CITY OF ALBUQUERQUE

RE: 13200 Wenonah Ave SE
Singing Arrow Community Center
Grading Plan Engineer's Stamp Date: 8/15/19
Hydrology File: L22D055

Based on the submittal received on 9/5/19, the Grading and Drainage Plan cannot be approved until the following corrections are made:

C100

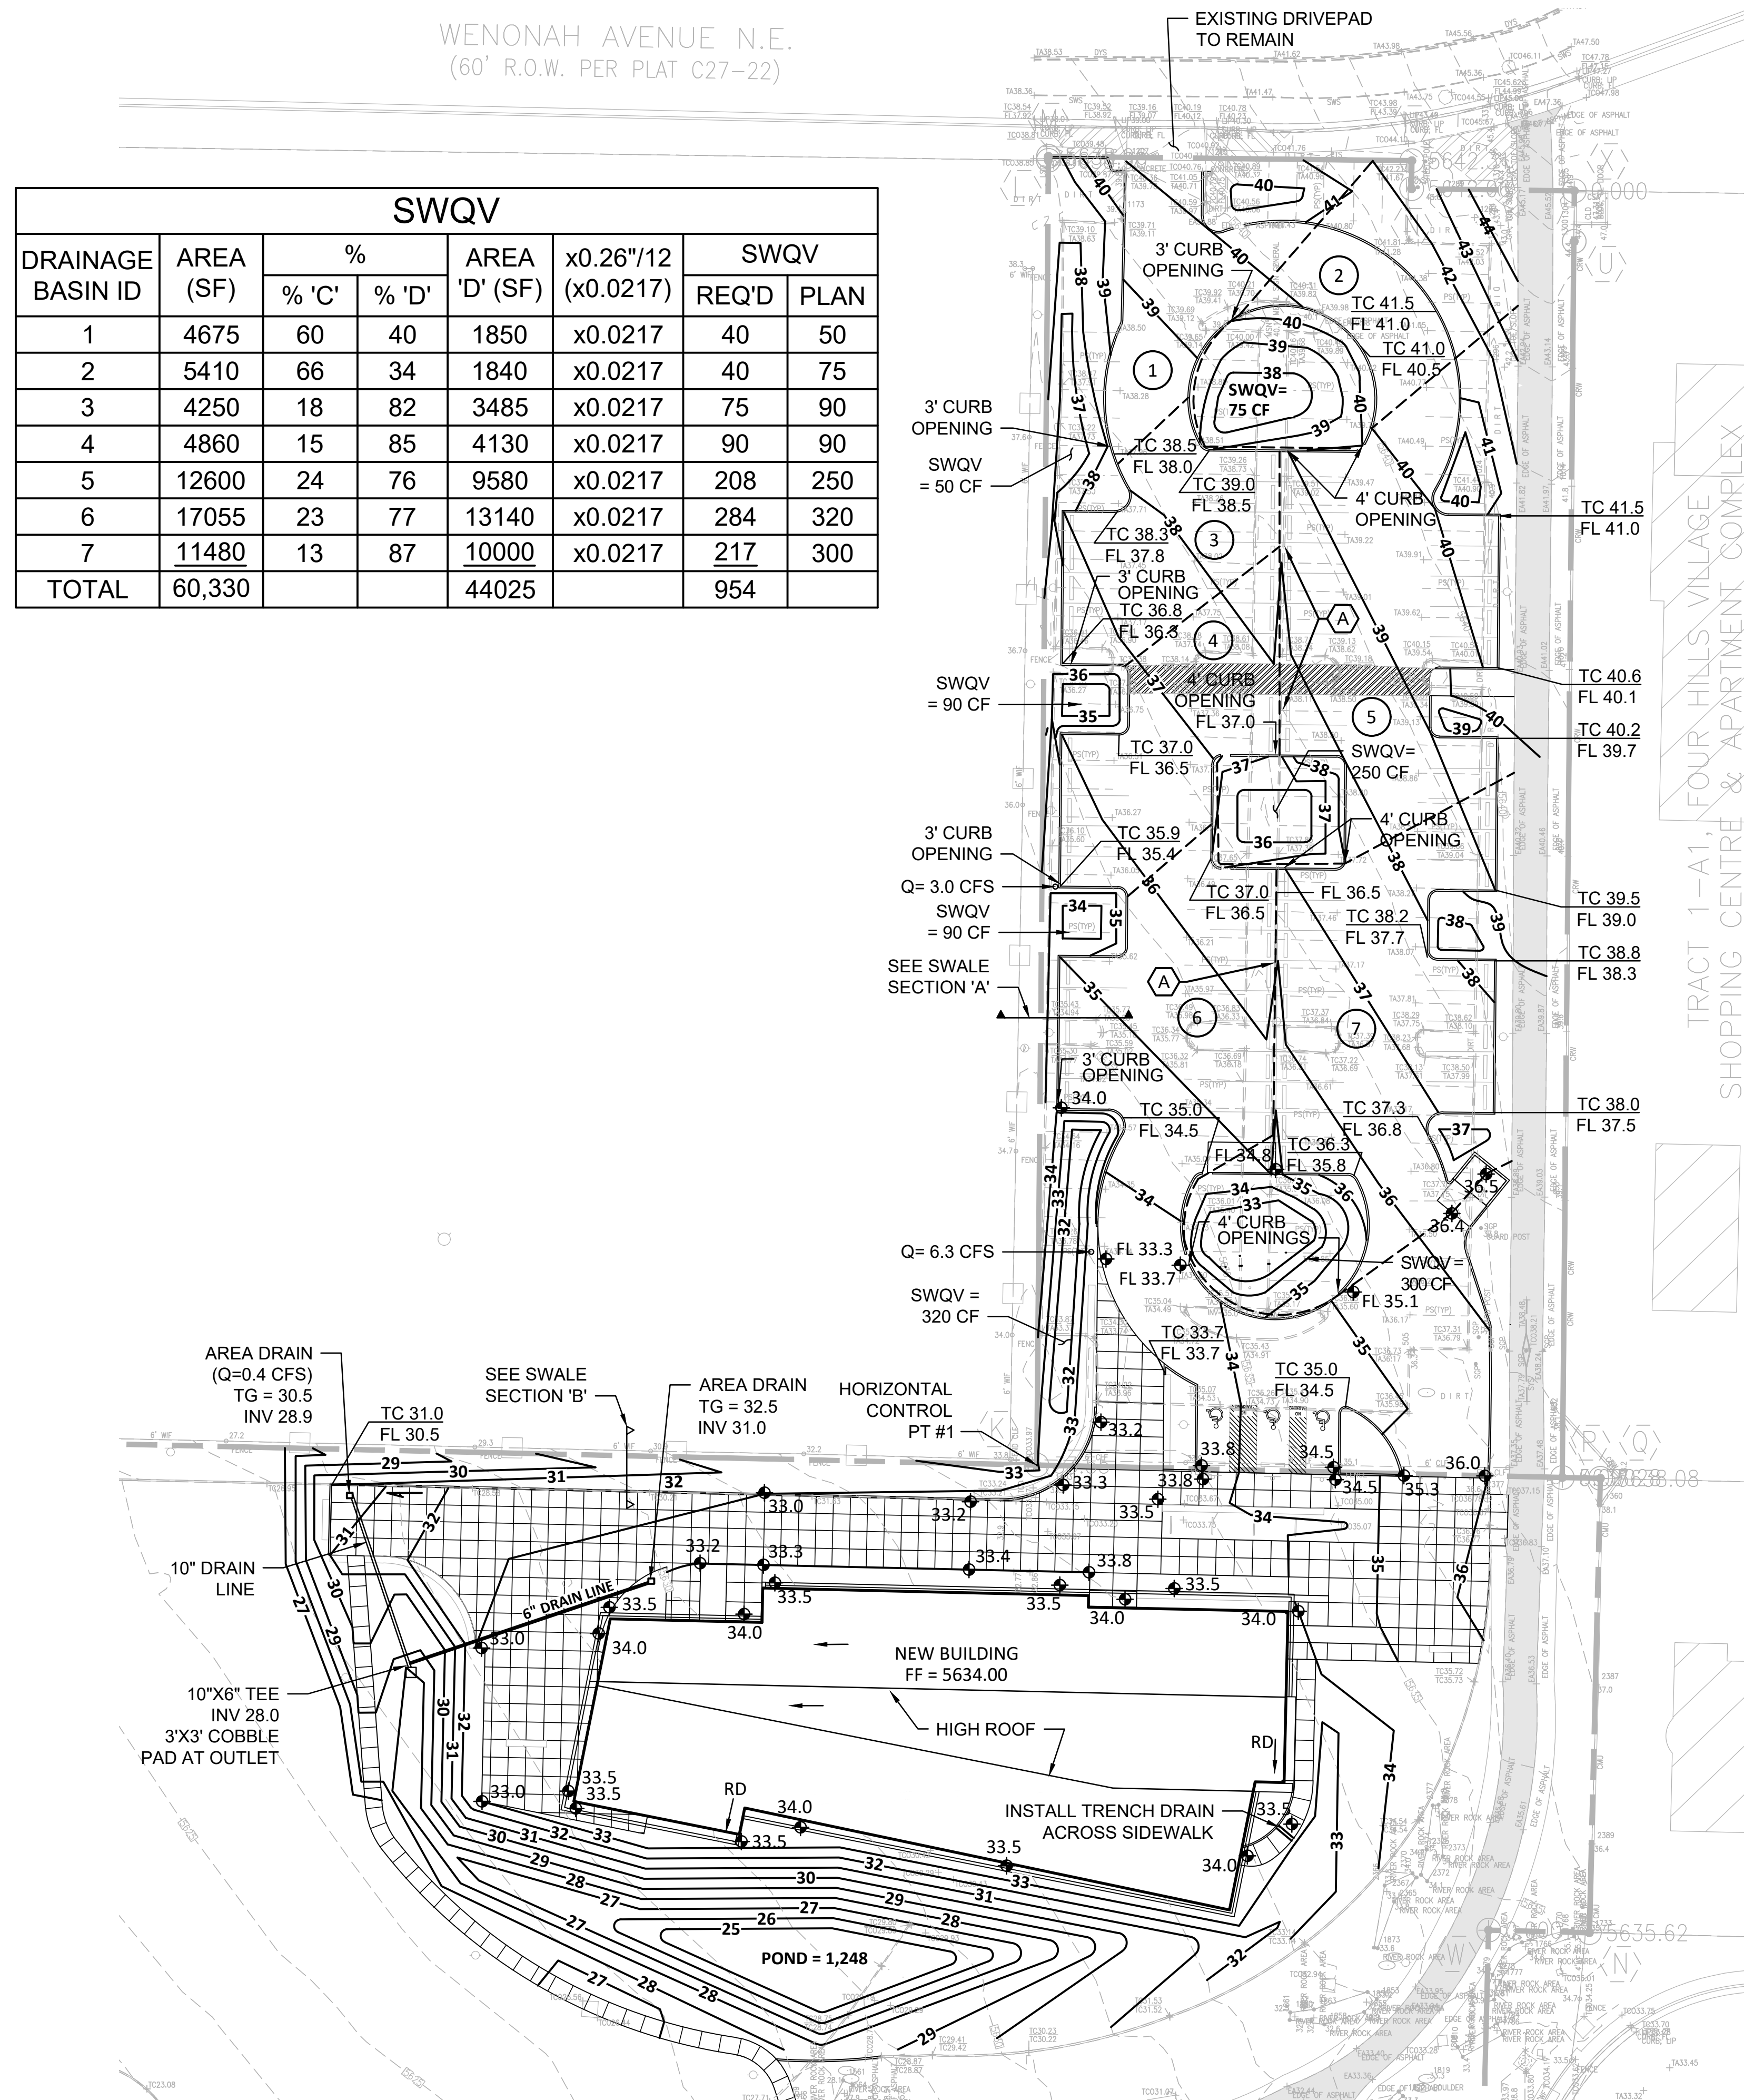
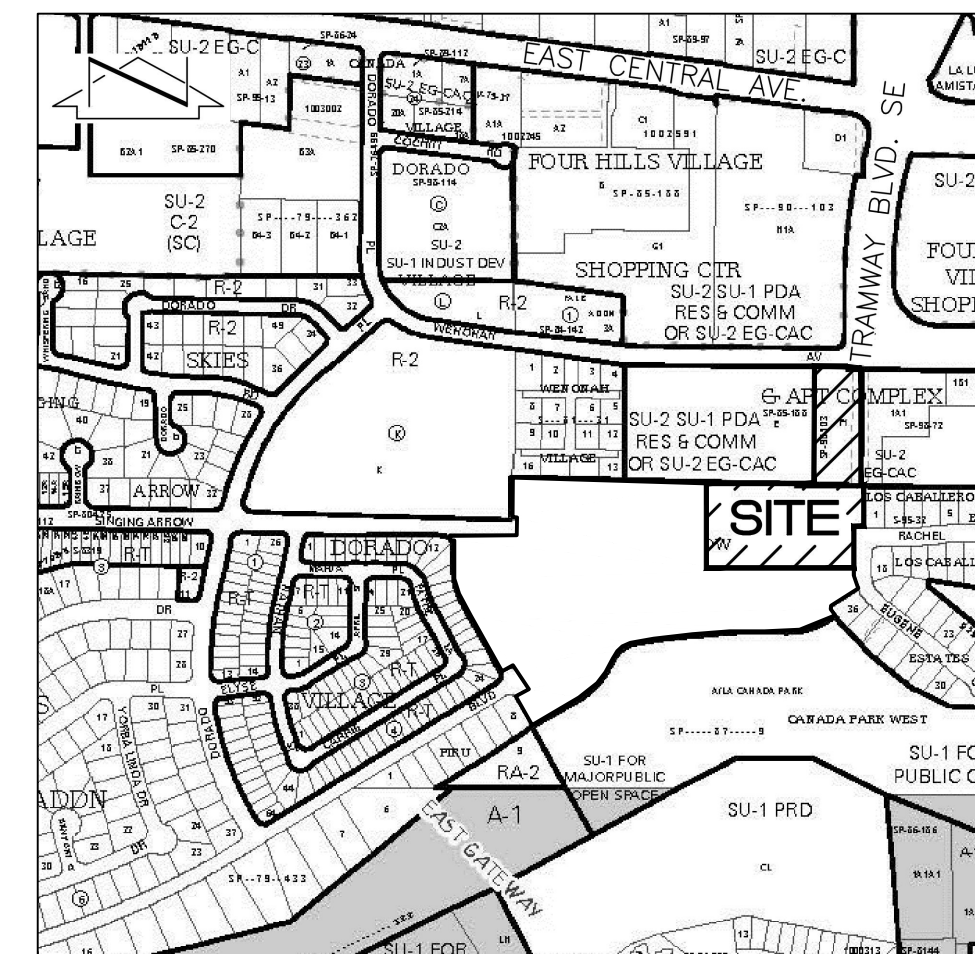
1. The drainage management plan for this site should include detention for the new impervious on Tract A and free discharge on Tract F-1. Runoff from both tracts drains through the undeveloped portion of Tract A to Singing Arrow Rd then to Tomlinson Dr where the drainage capacity of the street is exceeded and some of the existing houses are too low to prevent flooding. The existing parking lot on Tract F-1 is allowed free discharge since it was paved before the street capacity of Thomlinson became an issue. Runoff volume calculations for Tract A are missing and most of the runoff from the sidewalks and patio areas is not directed toward the pond.

2. Pond details are missing for the Tract A pond to include: pond volume calculations, using the conic sections method, pond routing, contributing basin, spillway details, to include supporting hydraulic calculations, pond sections showing the stormwater quality (SWQ) volume and elevation, the 100-year volume and elevation, the peak 100 year inflow and outflow, the spillway crest elevation, the spillway flow depth, and the berm top elevation.

3. Additional detail is needed on the SWQ pond along the property line with Hunter's Ridge Apartments to include: pond volume calculations, using the conic sections method, contributing basin, spillway details, to include supporting hydraulic calculations, pond sections showing the SWQ volume and elevation, the 100-year volume and elevation, the peak 100 year inflow and outflow, the spillway crest elevation, the spillway flow depth, and the berm top elevation. There should also be an appropriately sized curb cut at the sag location to allow the parking lot to empty into the pond.

4. A waterblock, 0.87' high, per COA Paving Detail No. 2426, is required at the driveway entrance.

5. Provide the SWQV calculations for each basin draining to each pond. The stormwater quality ponds must be sized for the Storm Water Quality Volume (SWQV) for redevelopment (0.26") times the new impervious area that drains into each pond. The drainage basins draining to each pond must be identified on the plan and both the required SWQV and the volume provided must be shown on the plan.
